Our Ref: EG/25/13/

Application for Planning Permission for Works or Extension to a Dwelling

Development Provision of a drop kerb

Location 1 Hall Cottages Barnham Road Eastergate

SITE PLAN

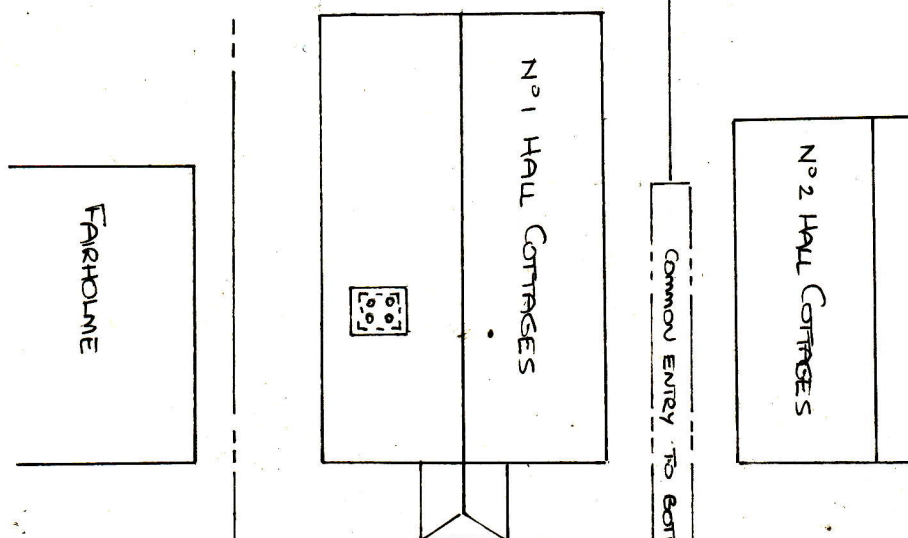
Please submit 1 electronic or 3 paper copies of a revised site plan with the visibilitys splays clearly incated in accordance with the guidance notes available on our website detailed below (click on National List). If you require further advice on visibility splays then please contact West Sussex Highways department, highways.western@westsussex.gov.uk
